Application for a Non-Material Amendment Following a Grant of Planning Permission

Demolition of existing store, shed and garage; construction of two storey side extension; erection of detached garage and loft extension with accommodation in the roofspace served by front/rear dormer windows and front rooflight, relocation of entrance door, front porch canopy, rear juliet balconies, alterations to fenestrations detail including replacement of doors and windows, internal alterations with associated front/rear landscaping works including alterations and extension to driveway.

23/1401/FUL

Blocking up small window in the Kitchen

Proposal proposed layouts

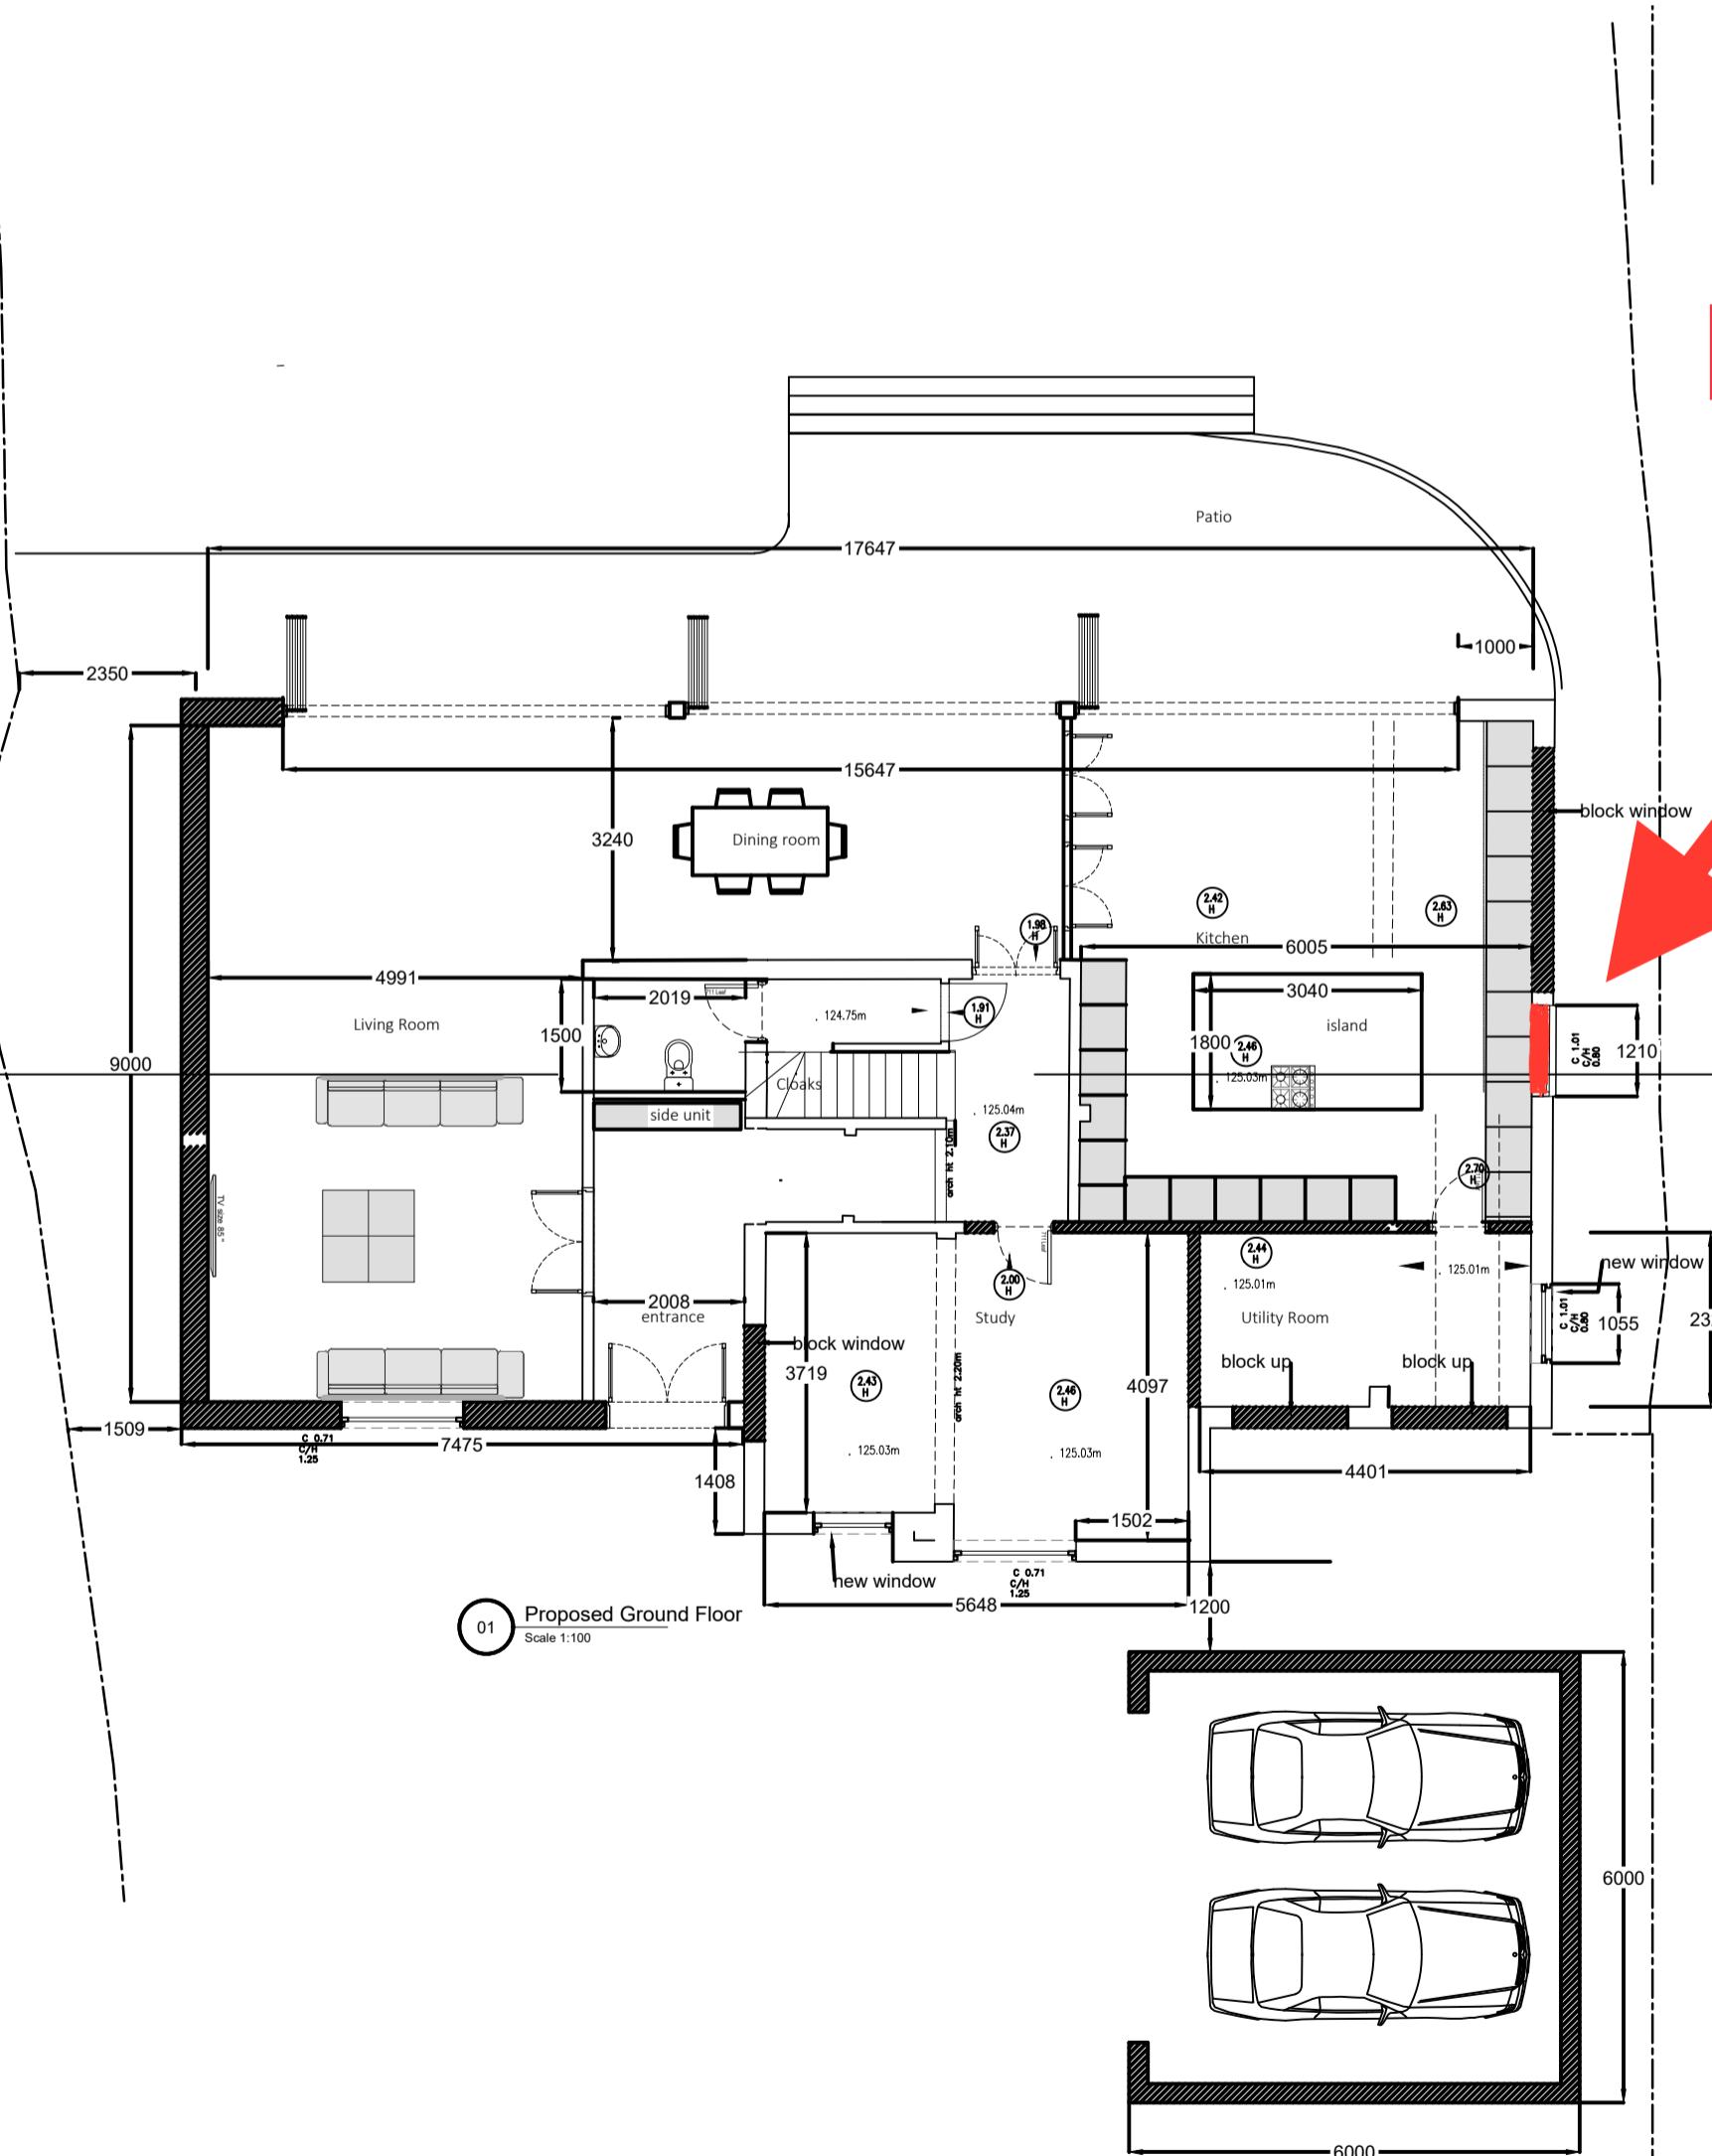
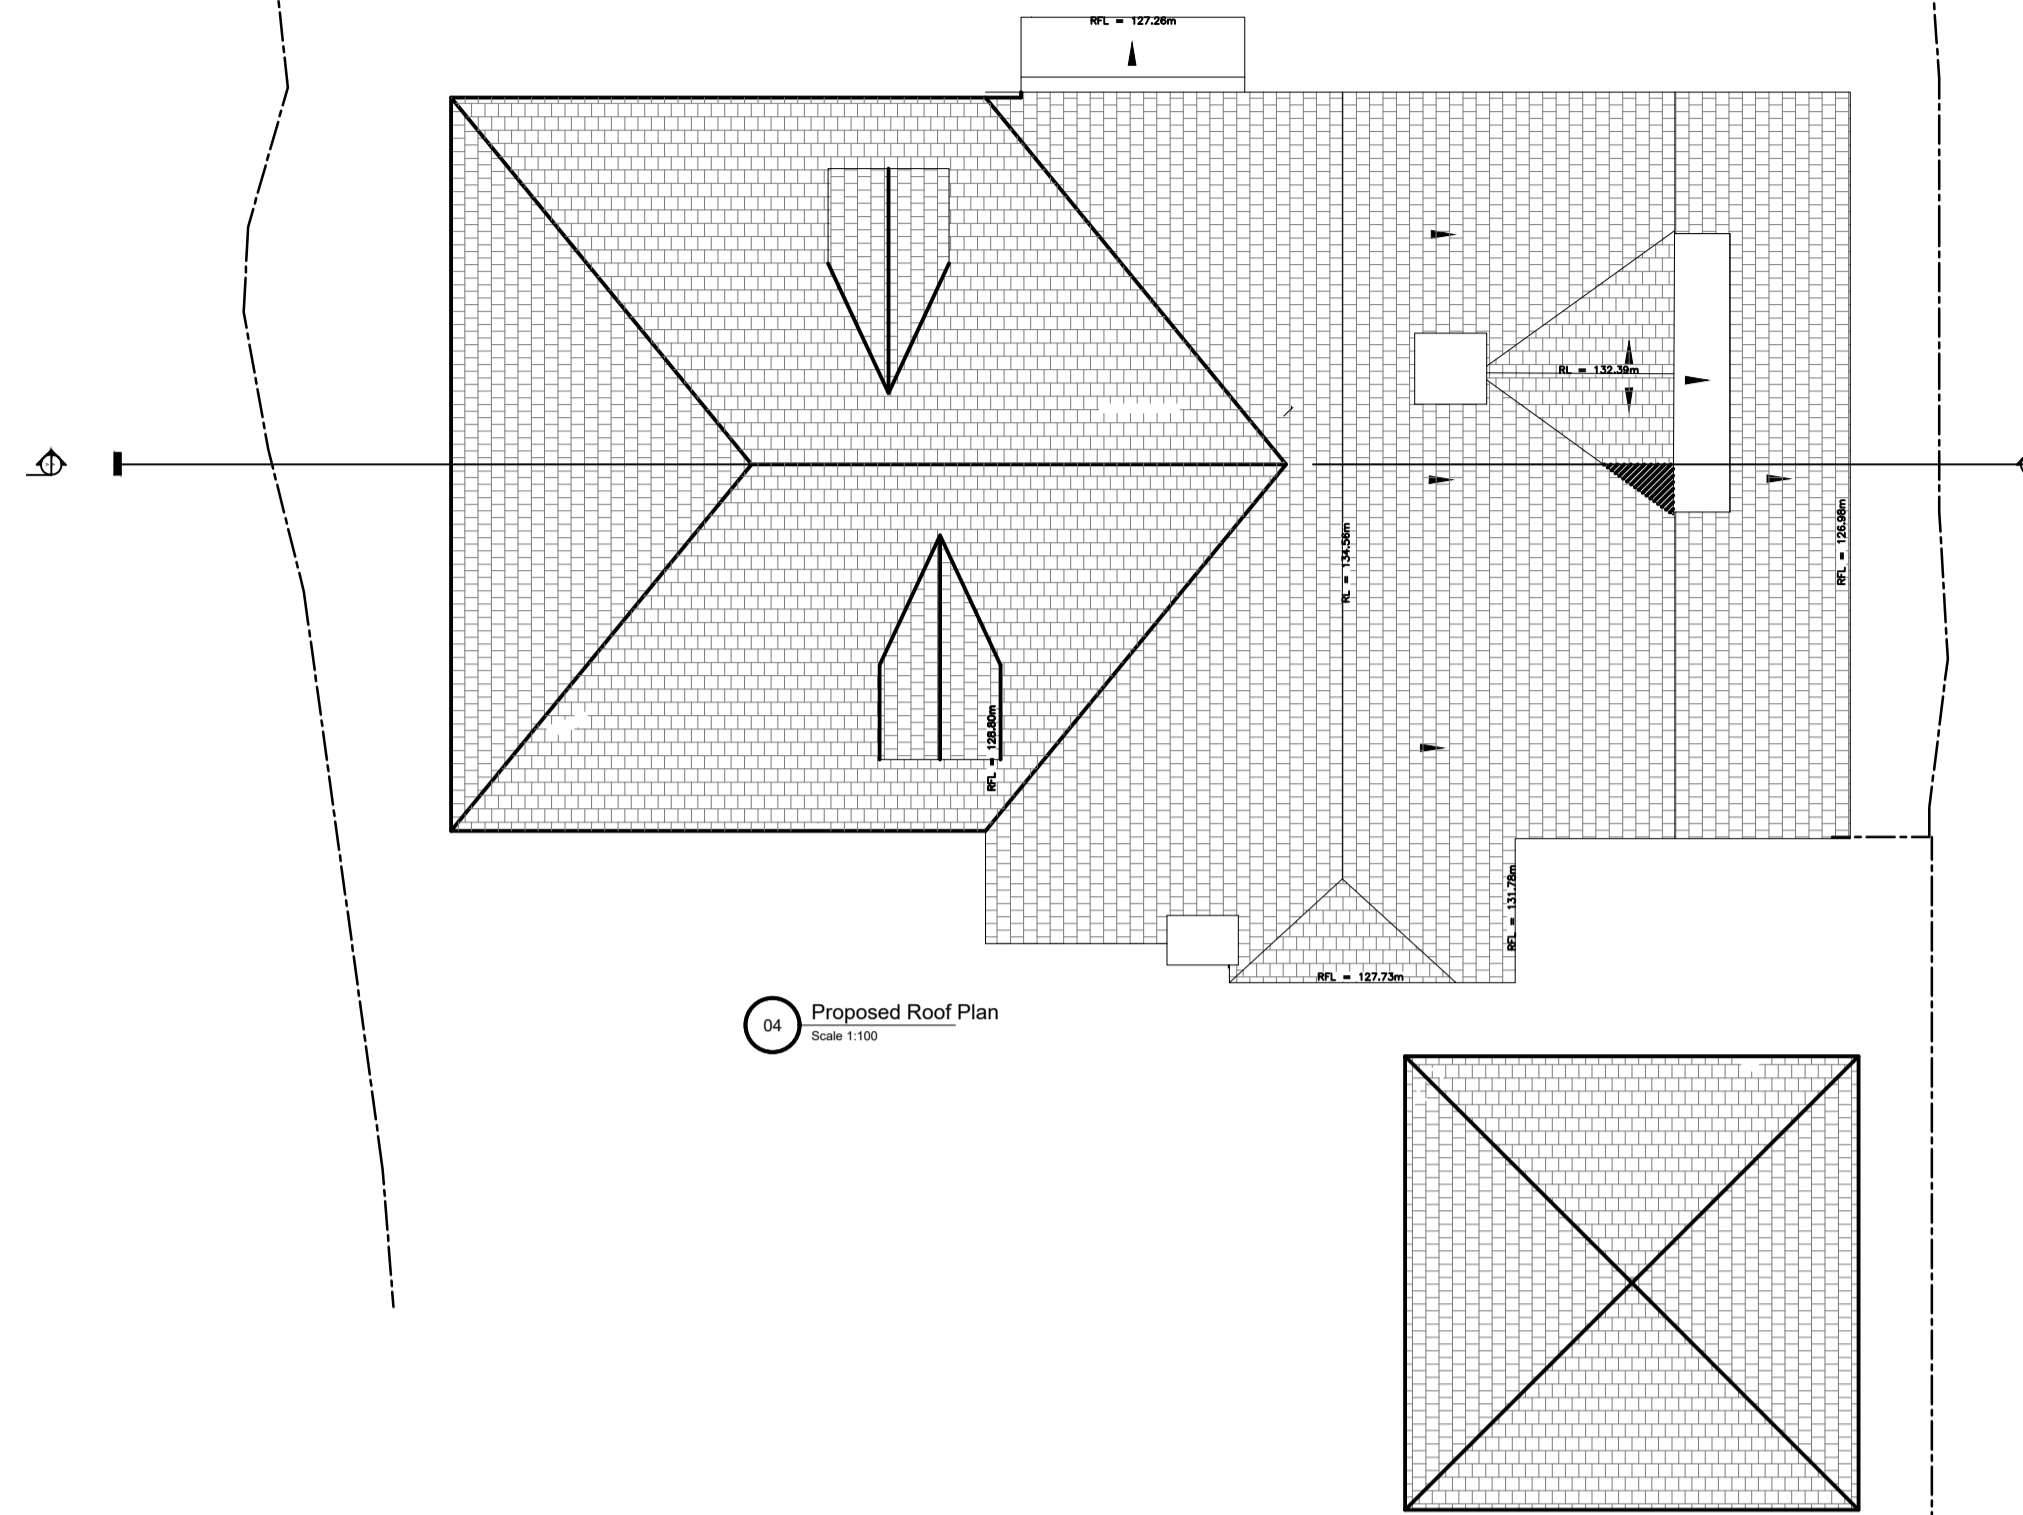
To allow for a better kitchen layout. The kitchen already benefits from a 5m wide floor to ceiling sliding doors to garden so there is plenty of light.
